**SEAS DEADLINE 6 RESPONSE to APPLICANTS's SUBMISSIONS**  
**SINCE DEADLINE 5, ISH3, Action Points and ExQ3**  
**LANDSCAPE & VISUAL and CULTURAL HERITAGE**

**PINS Ref:** EN020026  
**DEADLINE 6:** APRIL 13, 2026

**RE: SEAS Response to Applicant's Submissions since Deadline 5, ISH3, Action Points and ExQ3 – Landscape & Visual and Cultural Heritage**

# EN020026 SEA LINK DCO – DL6: RESPONSE BY NICHOLAS BRIDGES

Figure 1. EN010077-001489-6.2.29.7 EAIN ES Figure 29.7 Onshore Substation ZTV (with landscape character)

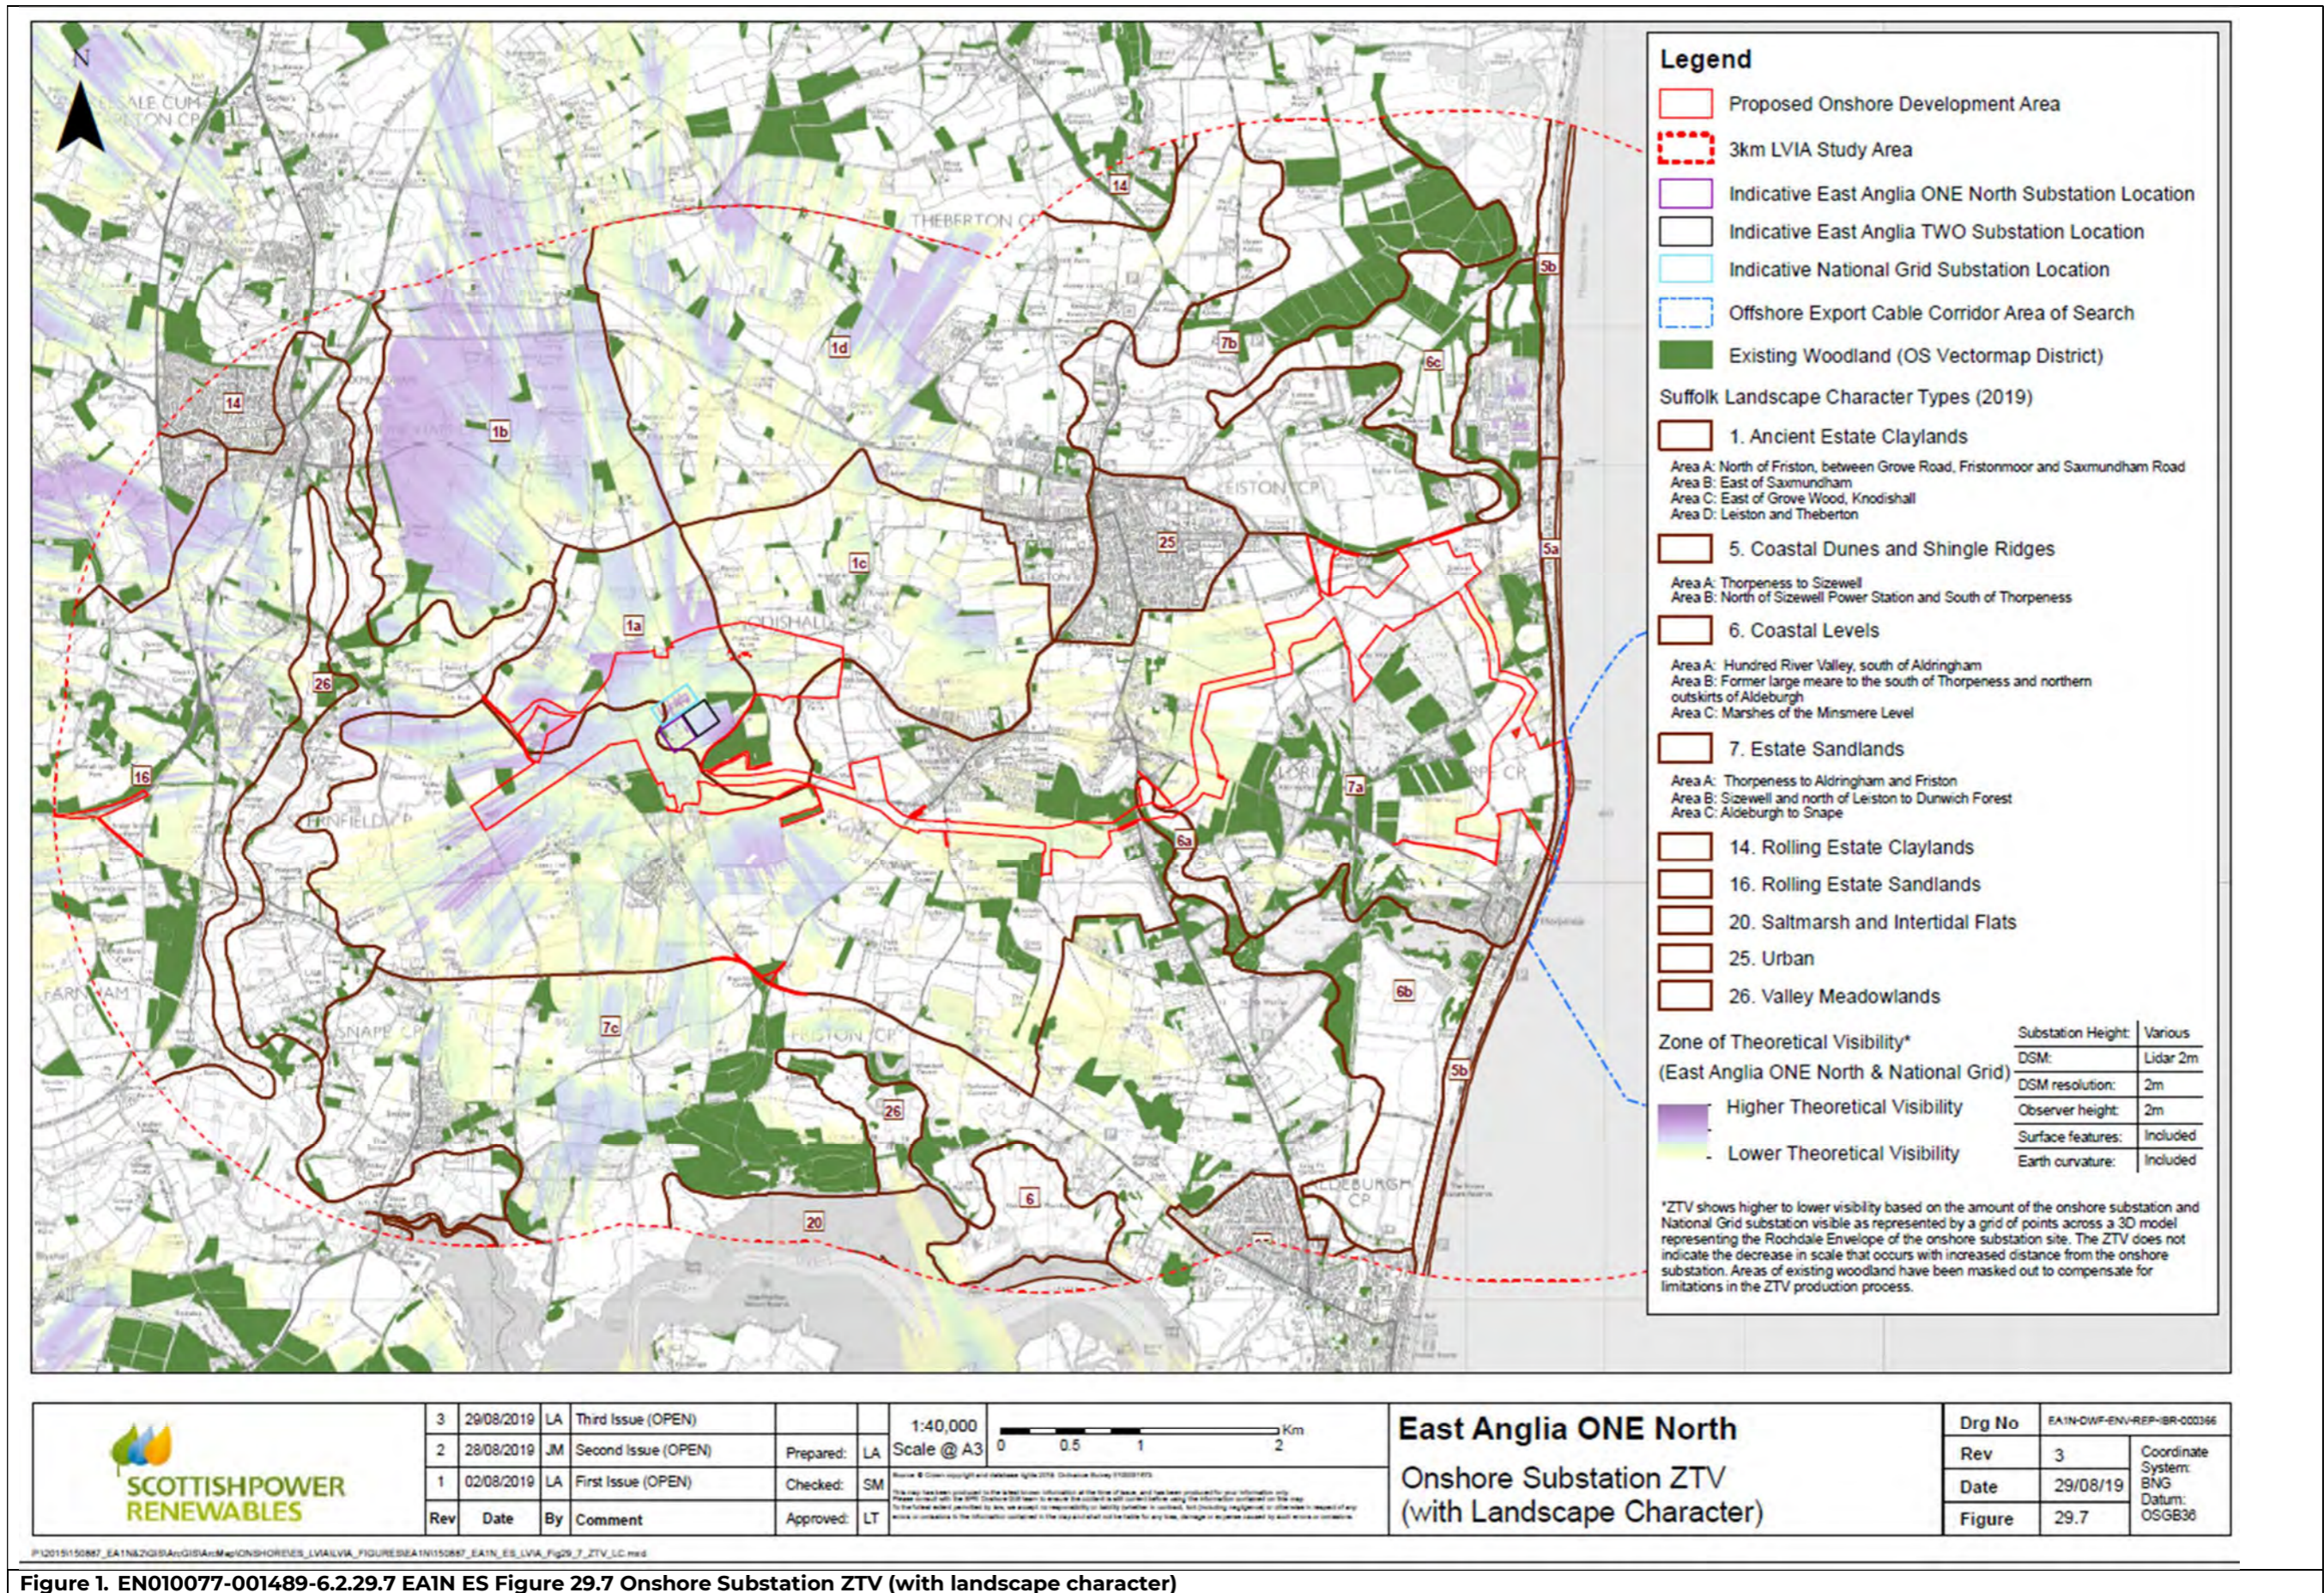
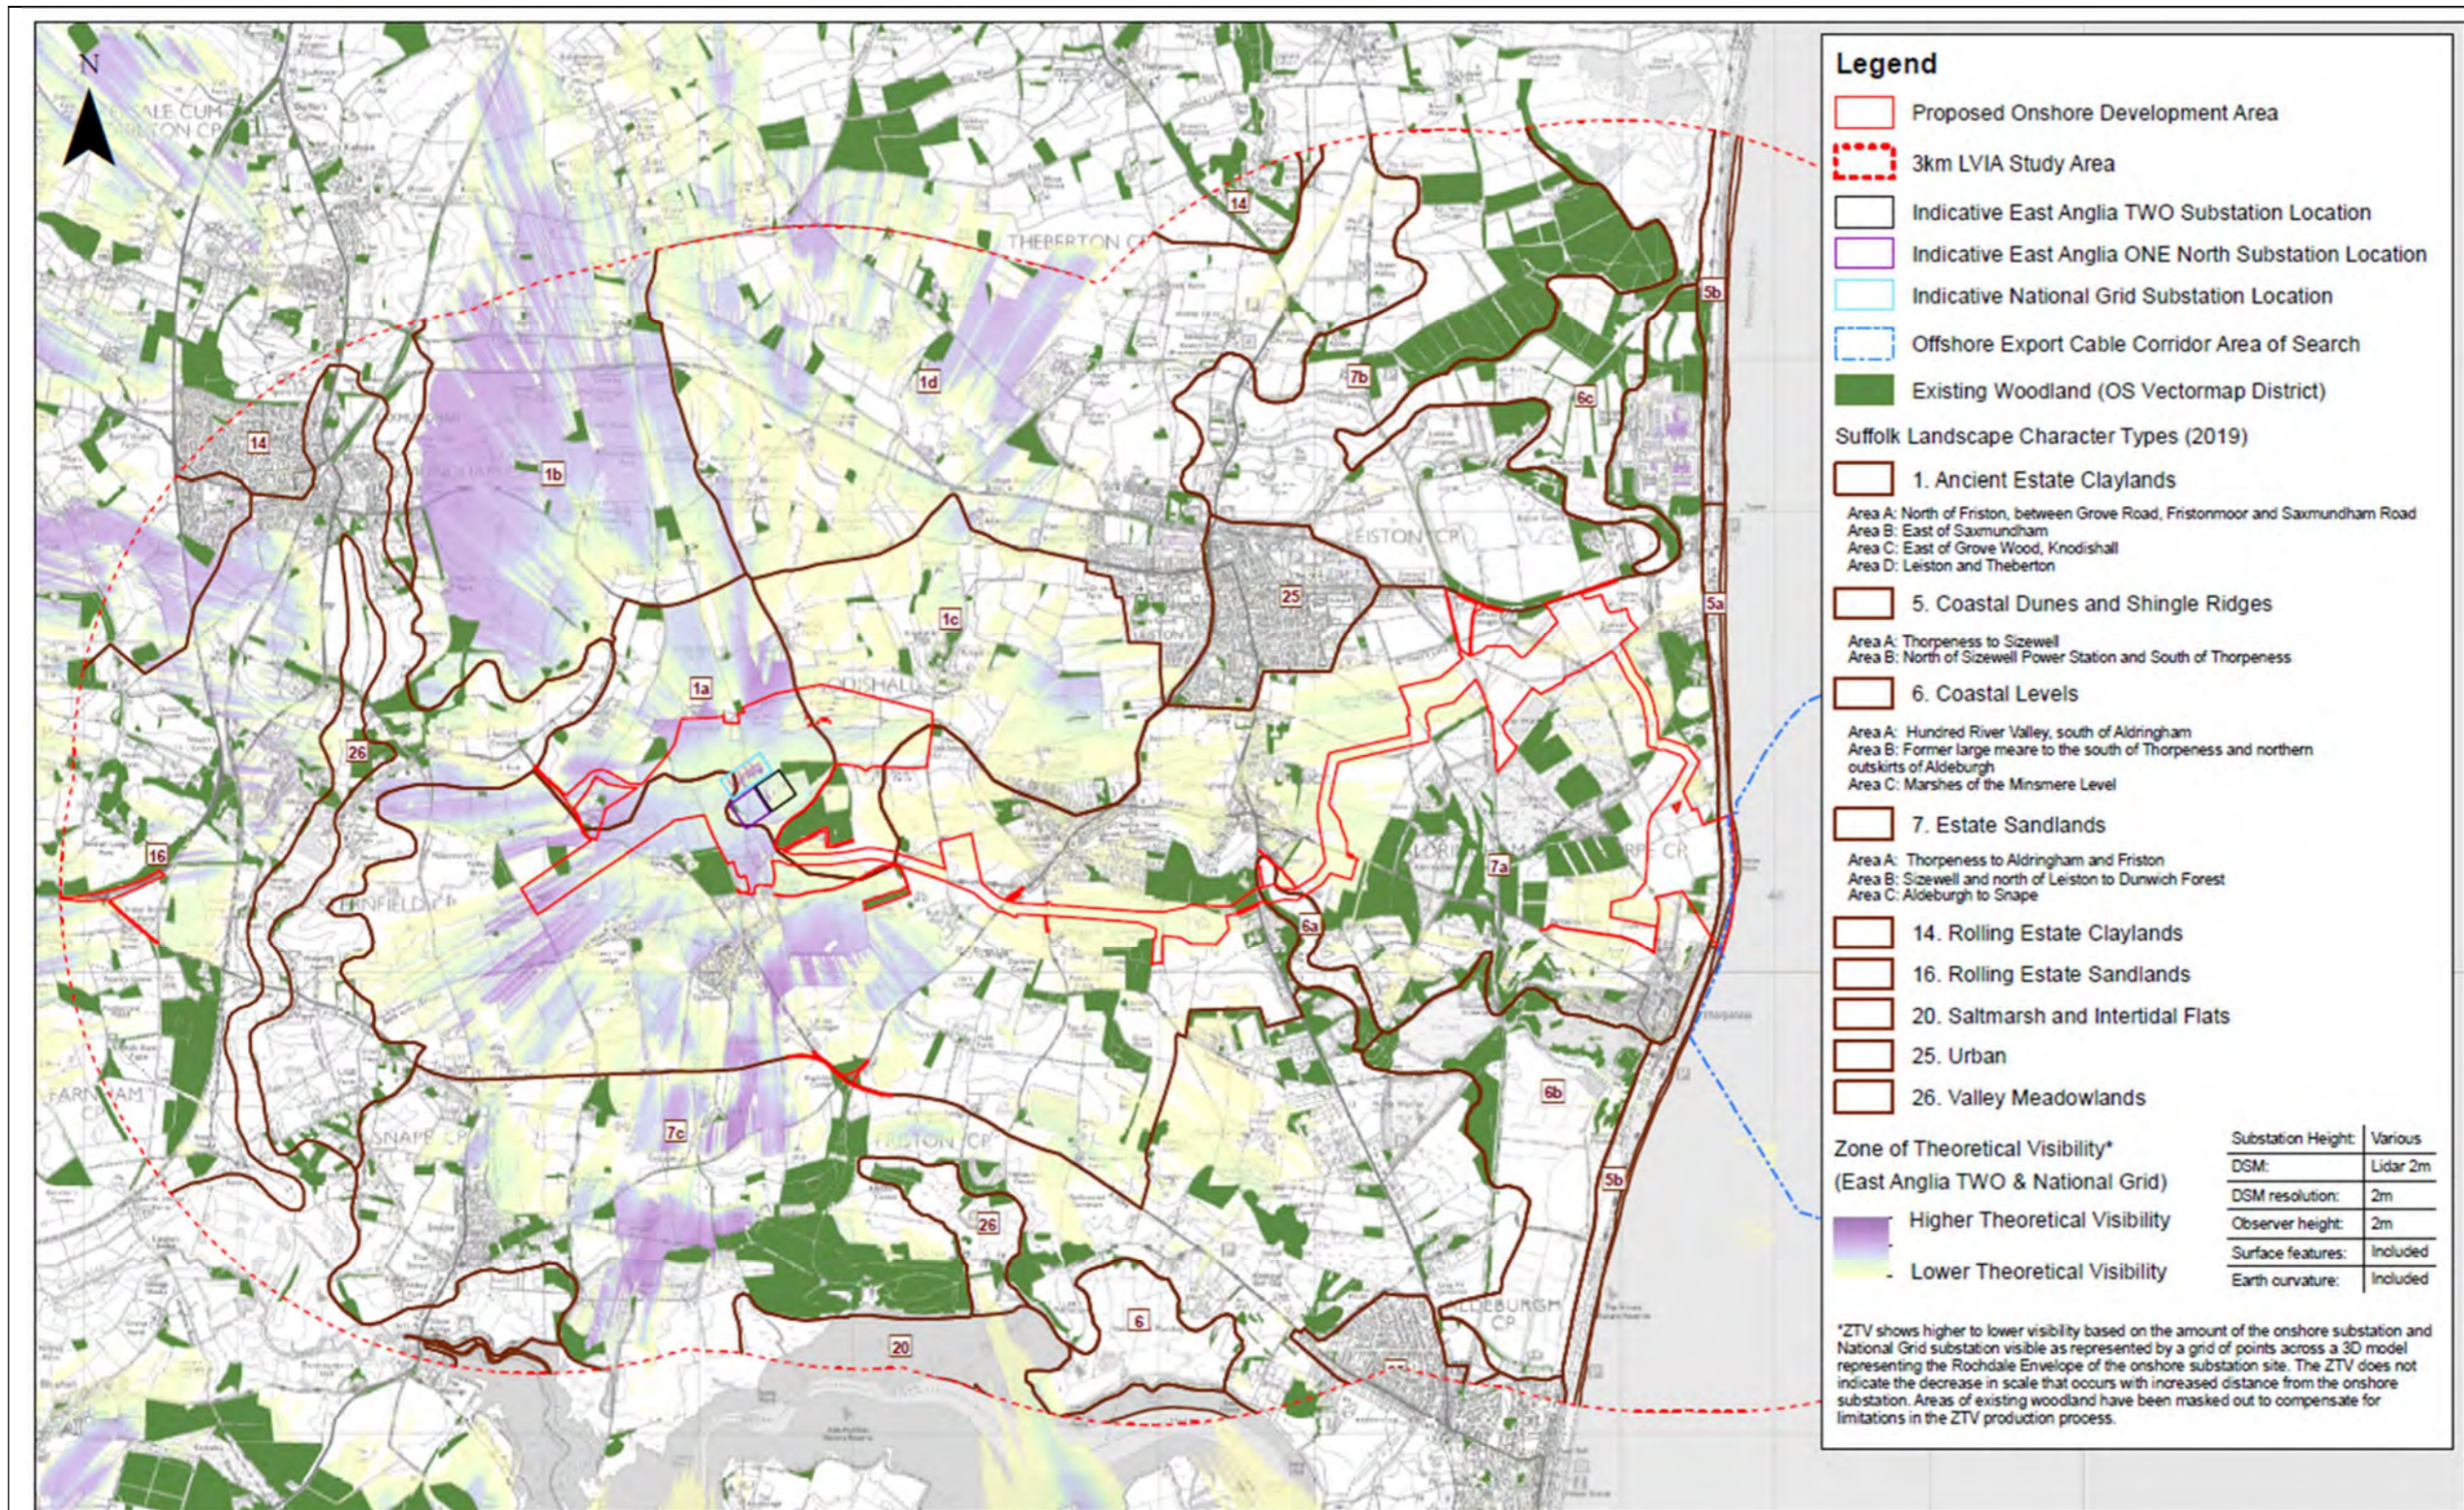
2.9. The ZTVs of the two Friston projects and Sea Link's PEIR have a similar pattern of visibility around their projects (see **Figures 1 to 11** below). Sea Link includes the National Grid substation at Friston which each of EA1N and EA2 also included. All Projects were modelled using OS contours, woodland and buildings at a generic height. Observer heights were a little higher for EA1N and EA2. The two Friston substations used the same parameter model as Sea Link.

2.17. The applicant does not seem aware of the EA1N and EA2 ZTV plans (**Figures 1, 2 and 3** below) which show that those developments would be visible. Nor the Sea Link PEIR likewise. Visibility from the top of the church tower is not relevant as the public have no access nor is it important as a private viewing point, unlike the Martello Tower for which this use was its primary function.
